From: [REDACTED]
Sent: 11 May 2026 14:35
To: Planning
Cc: Planning Enforcement
Subject: Application 3/2026/0287

We have looked at the above application and are concerned about certain points.

5 Proposed Site Plan  
1 : 500

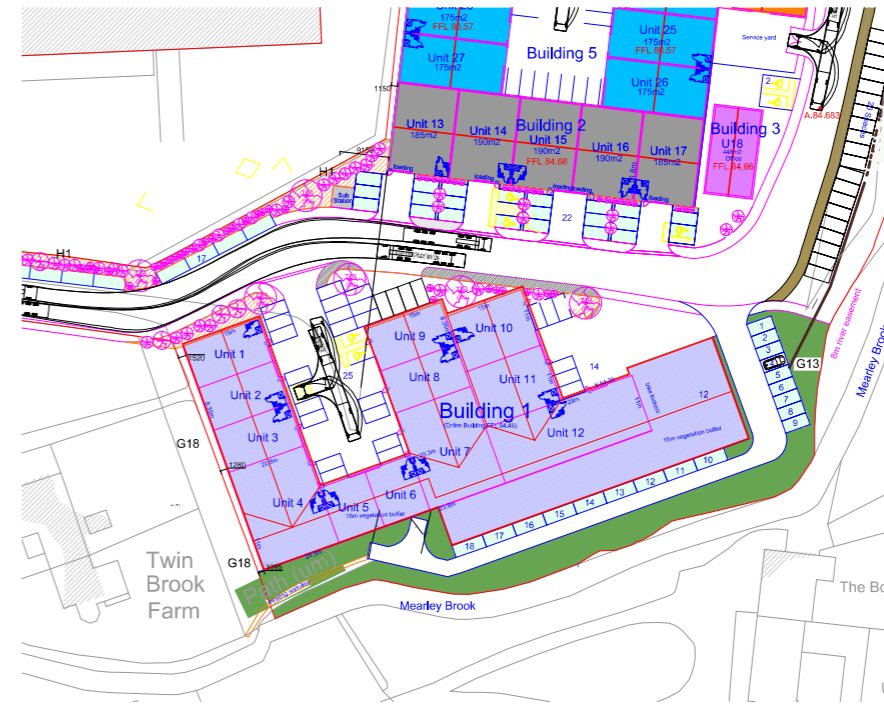
3 The proposed road and parking areas on the brook side of the development will result in the footpath being replaced by a road and in places it is very close to the brook. It would also mean the removal of some existing mature trees thus limiting the existing brookside screen.

4 There must be no possibility of the proposed access road to the parking area being extended to link up with Upbrooks Lane even though the developer owns both sites. There must be no possibility that the building site at Twin brooks farm with planning for two houses, owned by Mr Alpe, not yet sold could in the future be included in the proposed industrial development by Penpod.
